Subject: FW: Comments Re: Planning Application 2022/91839
Date: 13 July 2022 10:55:46

Planning Application 2022/91839
7 Gatesgarth Crescent, Lindley, HD3 3LG
Erection of 2 storey side extension

Drawing Title: PROPOSED FLOOR PLANS,
ELEVATIONS & SITE PLAN

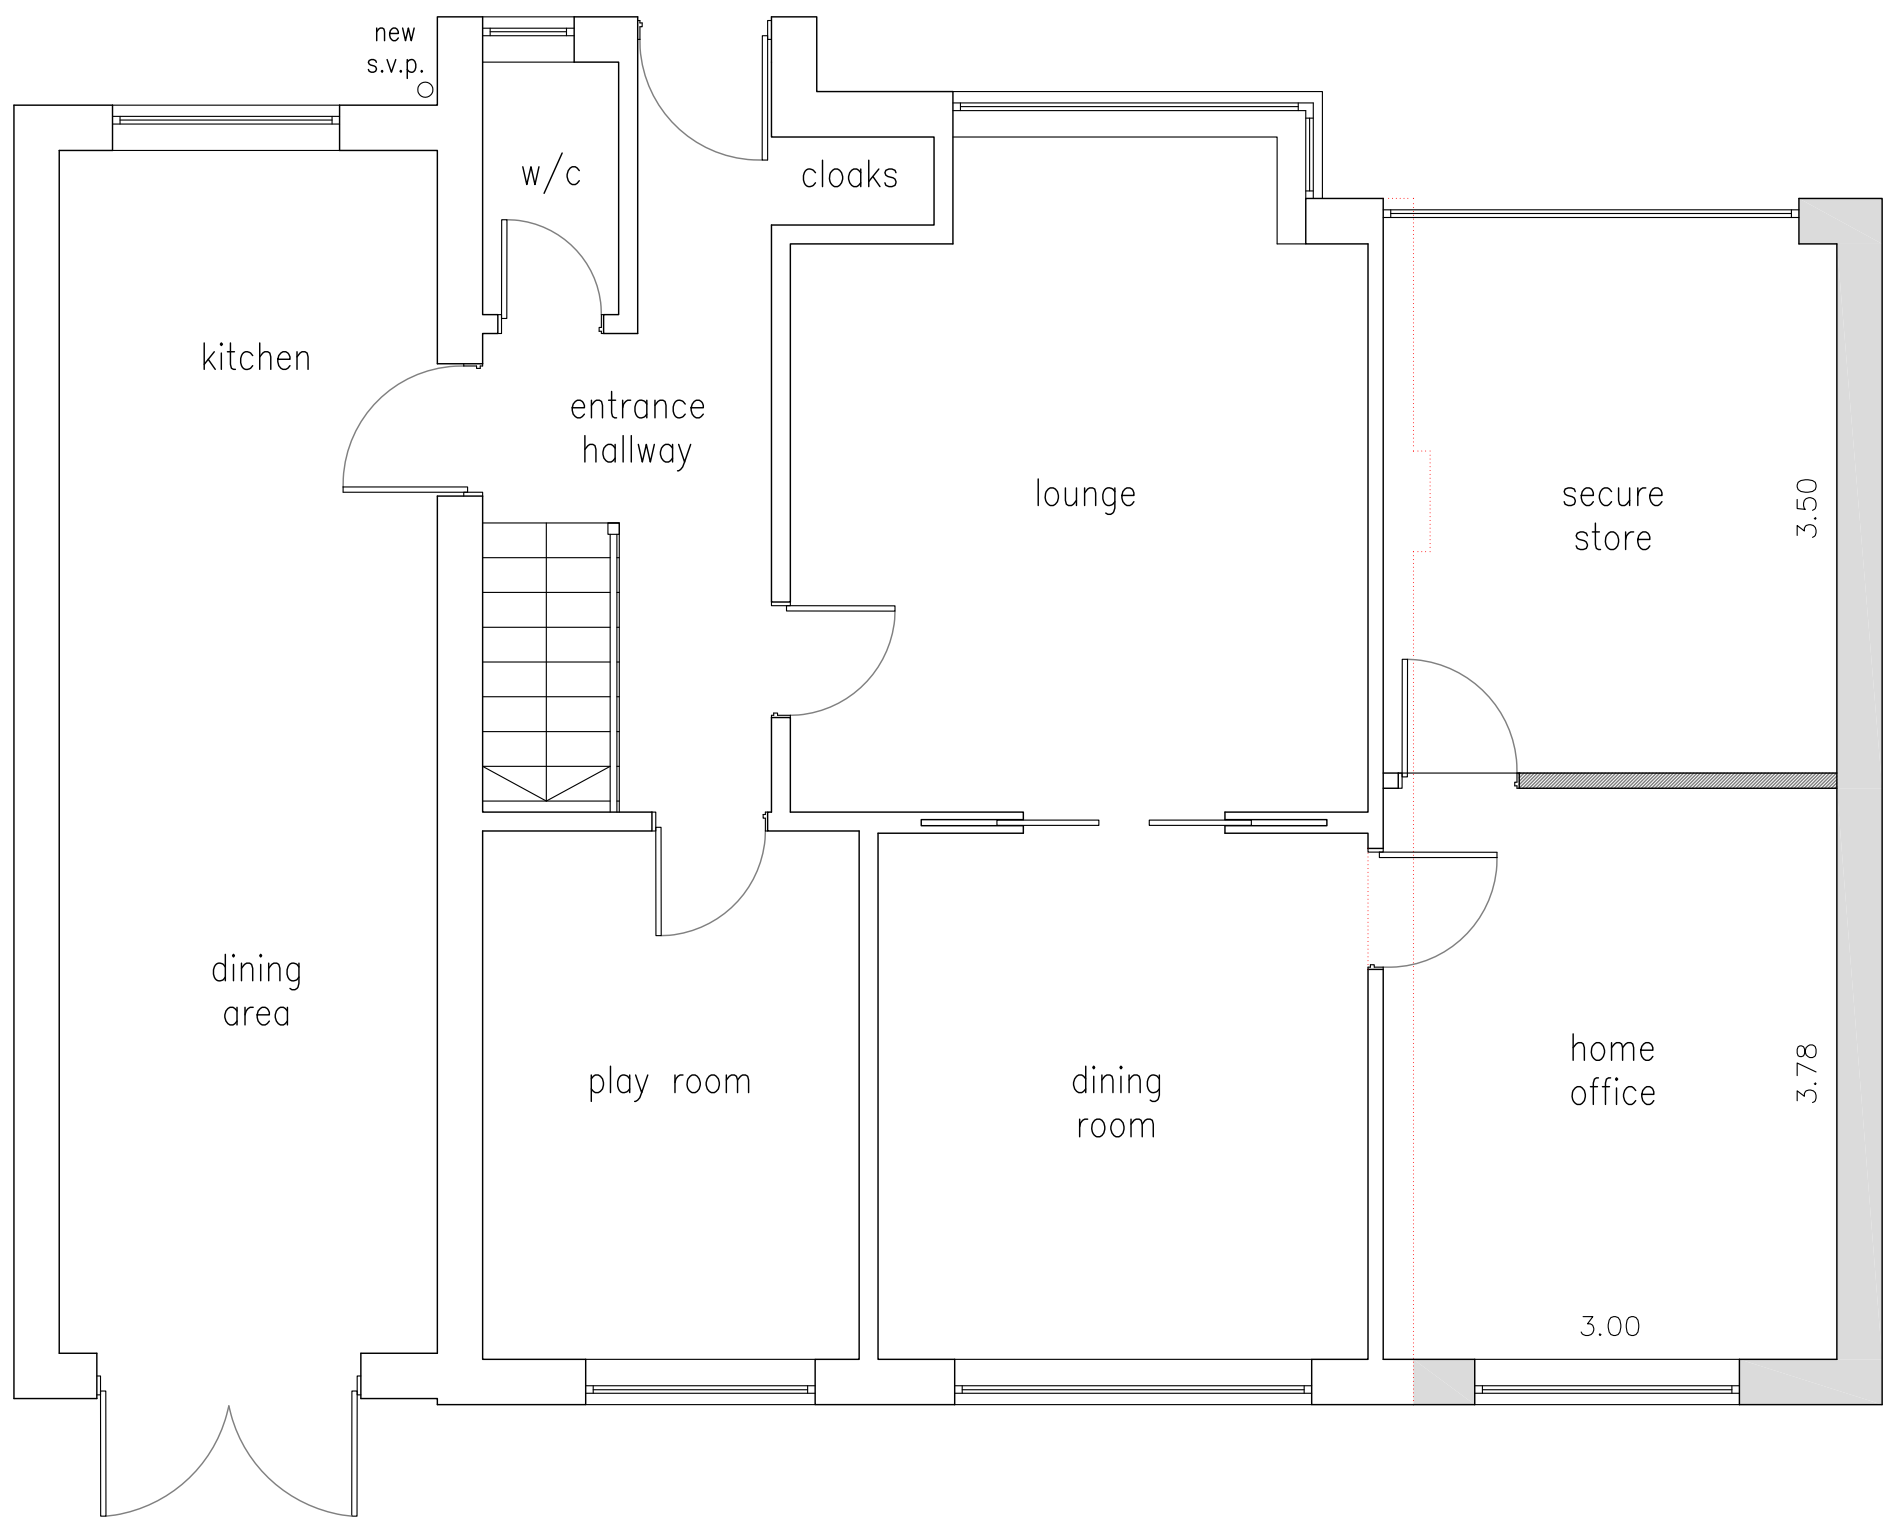
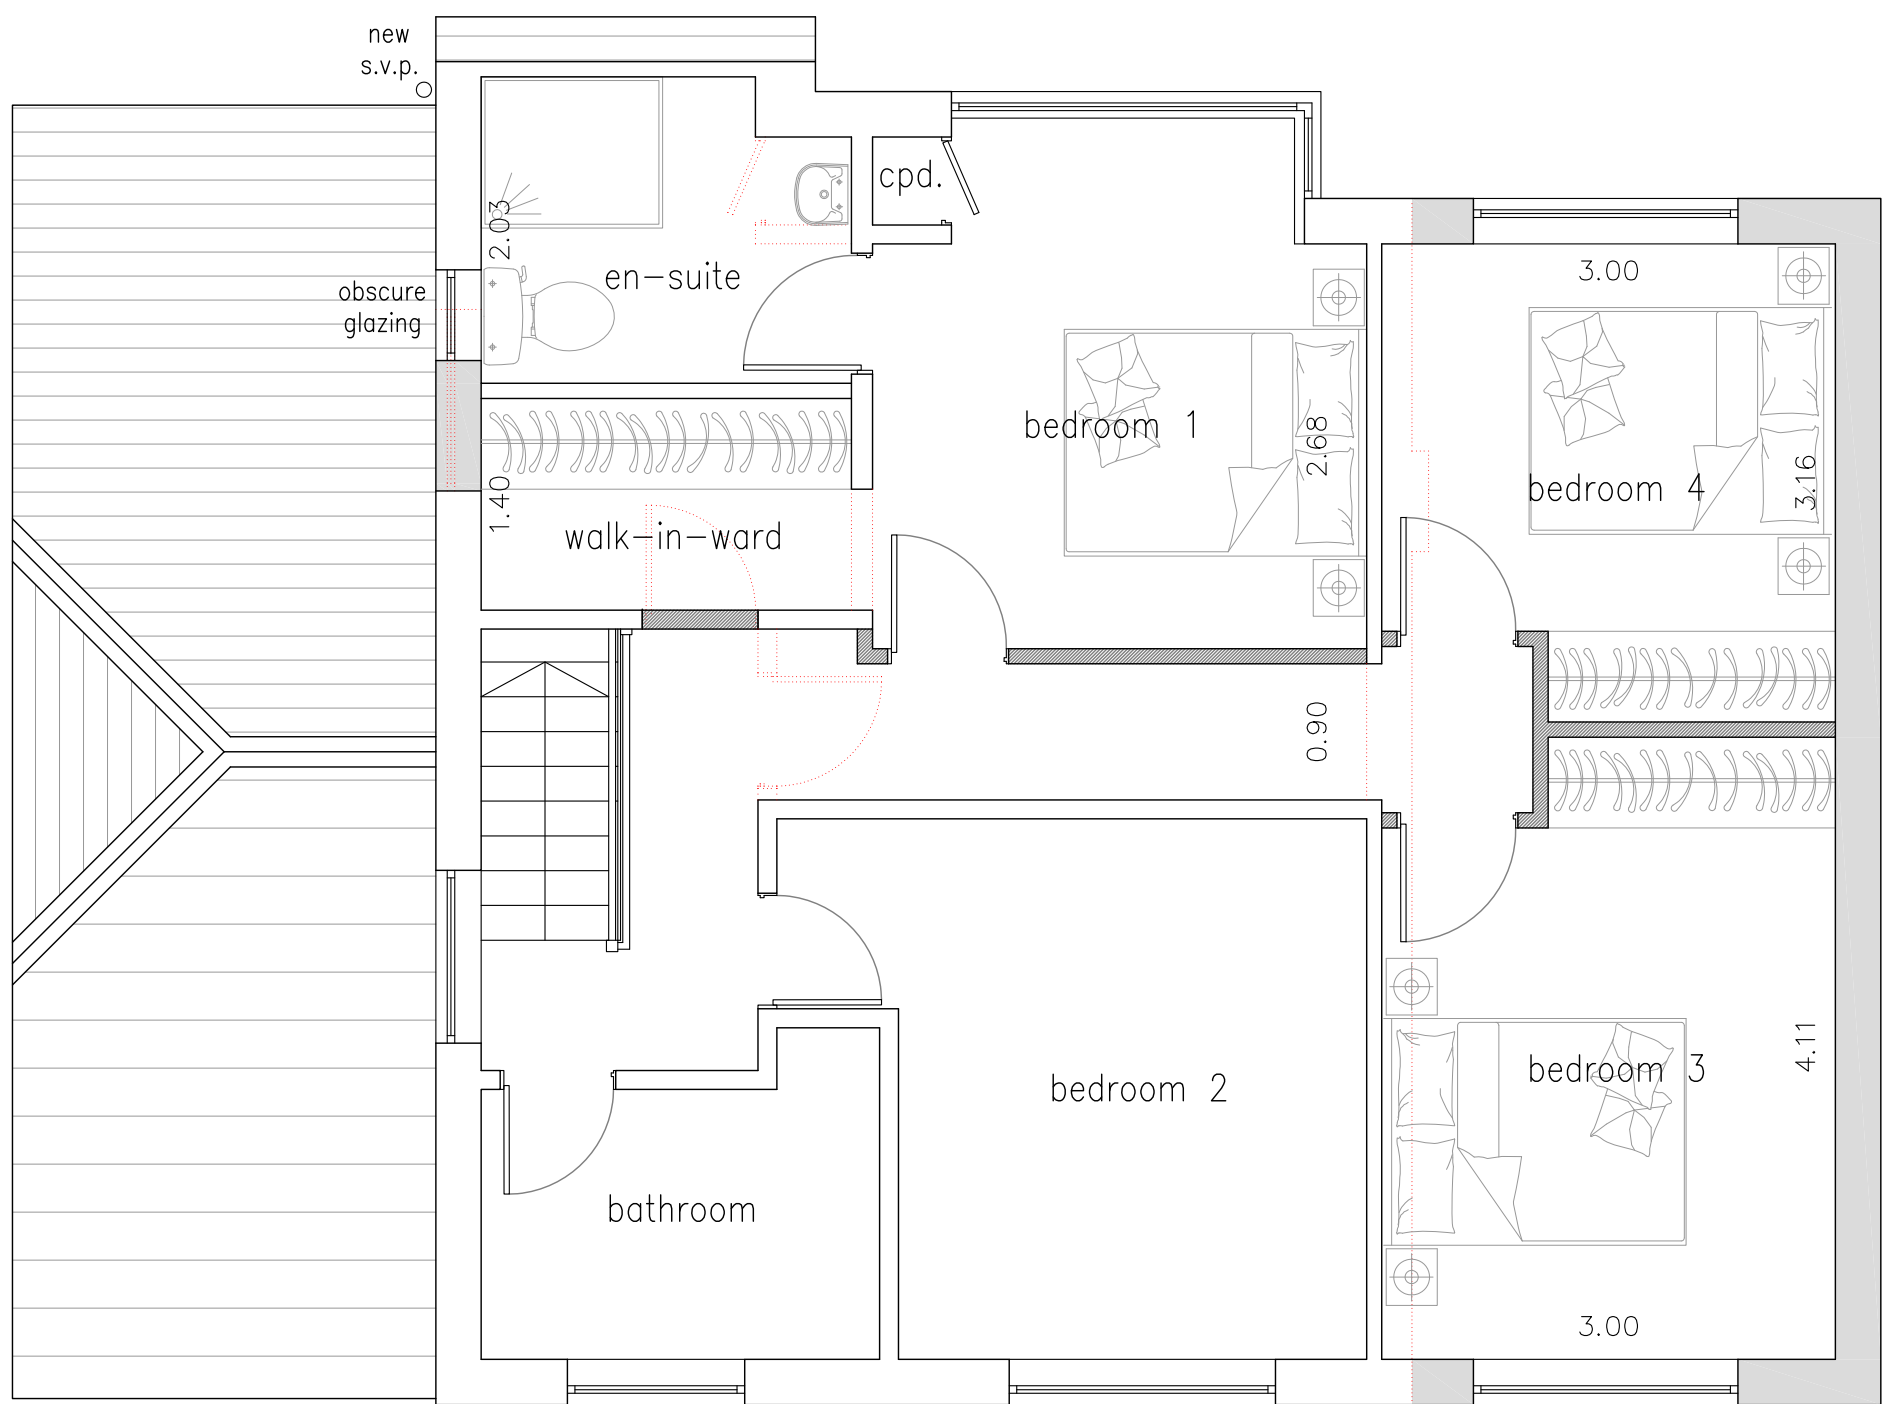
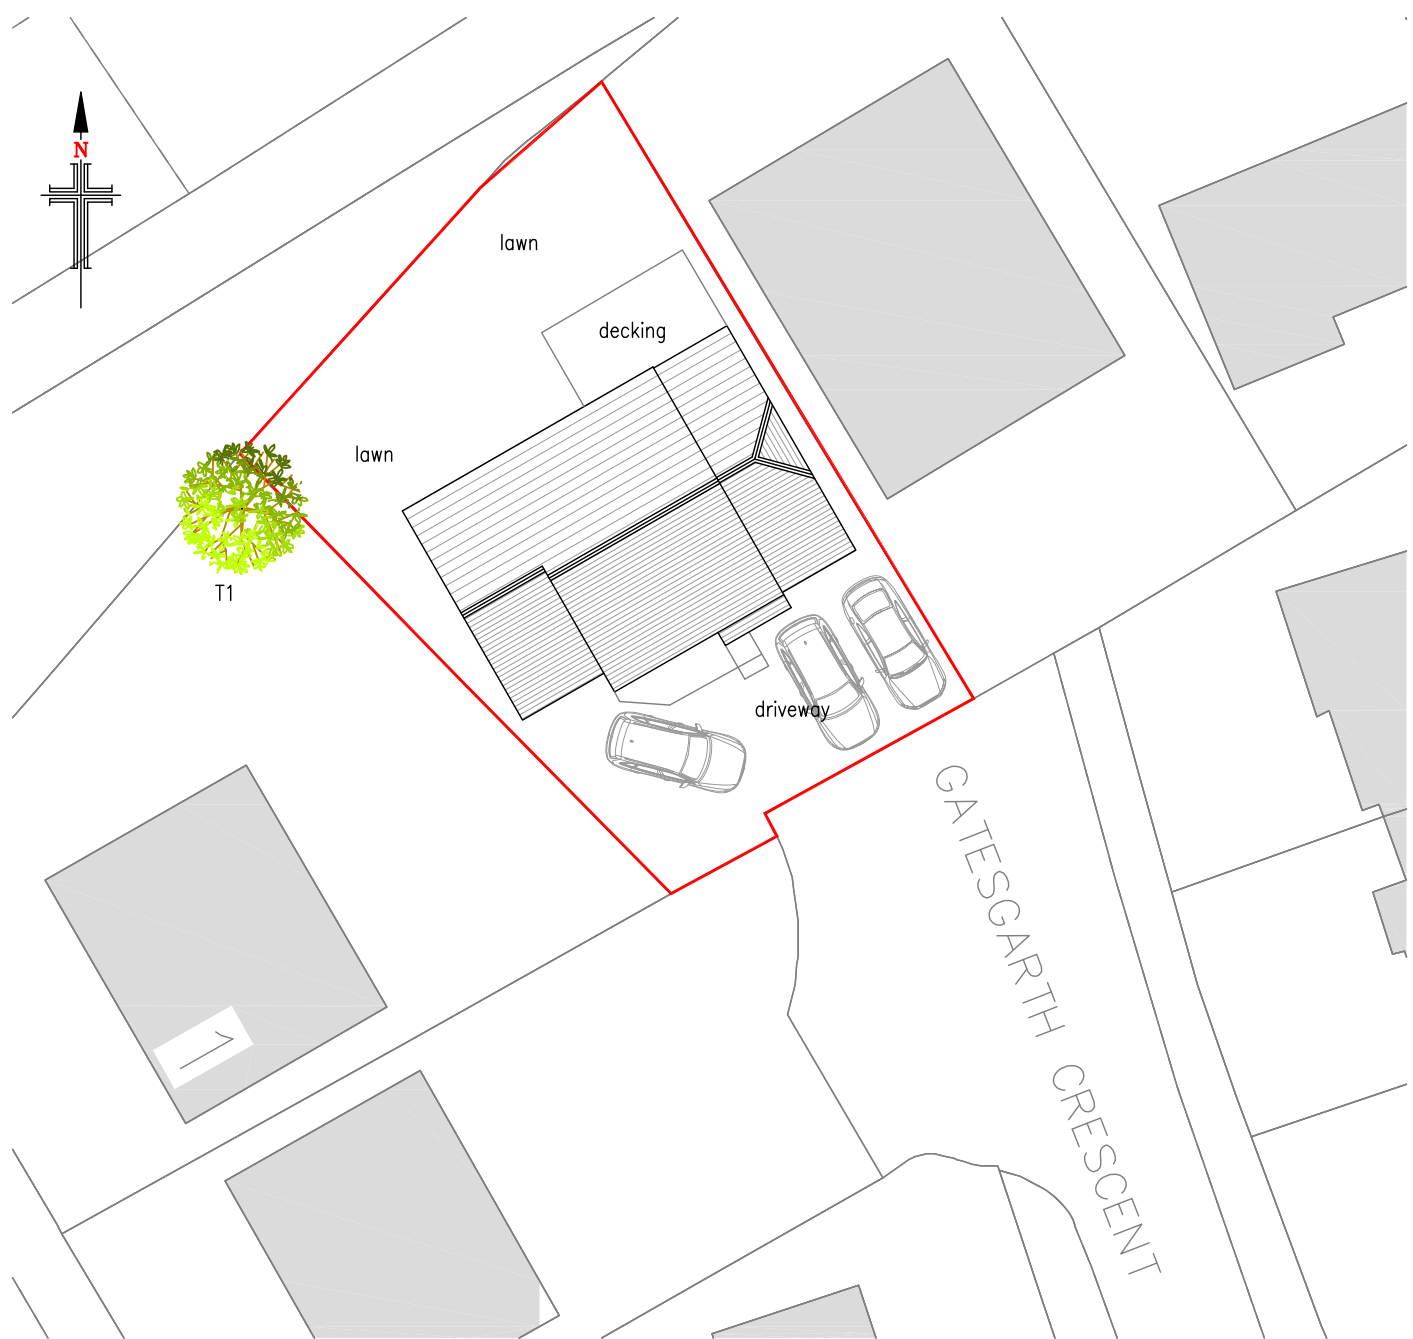
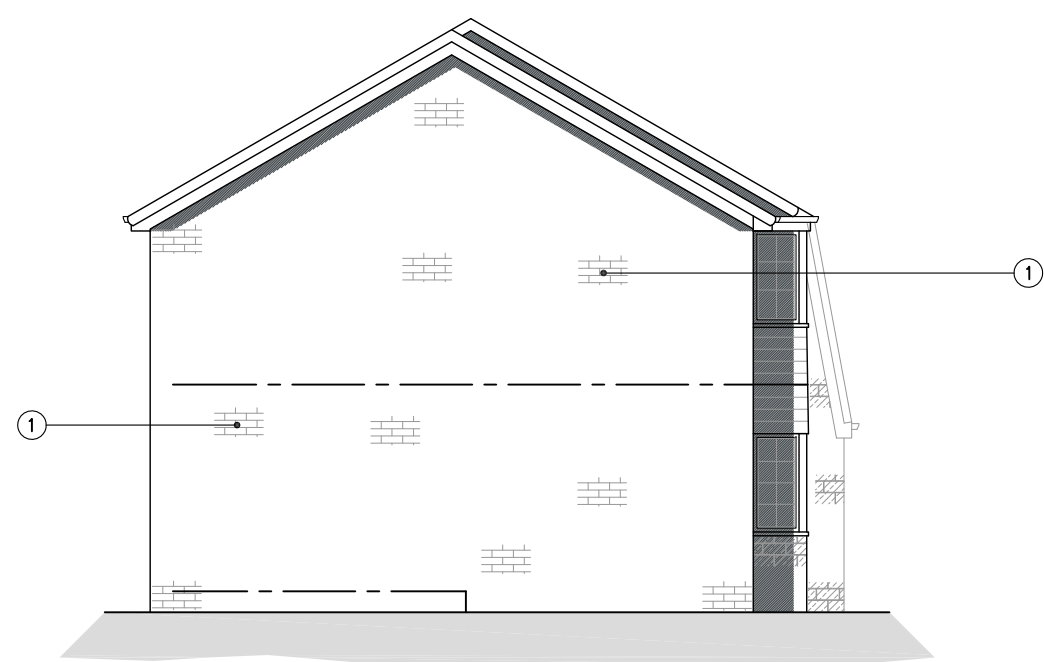
The size and scale of the extension in relation to the size of the original property and available land, and when taking into account the first extension, nearly doubles the footprint of the original house and also the original frontage of the house. This amounts to

overdevelopment of the site.

Given it's size and proximity to the boundary and the closeness to my property, a 2 storey extension, (at least 3m closer than the existing gable) will be overbearing and imposing, and I believe will have a detrimental visual impact from my windows and garden.

I am not convinced that there is sufficient space to build the extension on this site and maintain sufficient space for access to the rear garden.

Access to maintain the gable wall of this extension will be difficult to achieve within the property's own curtilage.

The excavations to construct the extension risk undermining my garden, as it means cutting into the banking.

Although no windows are proposed in the gable wall, there will be some overlooking of my garden and I believe will have a negative impact on my property.
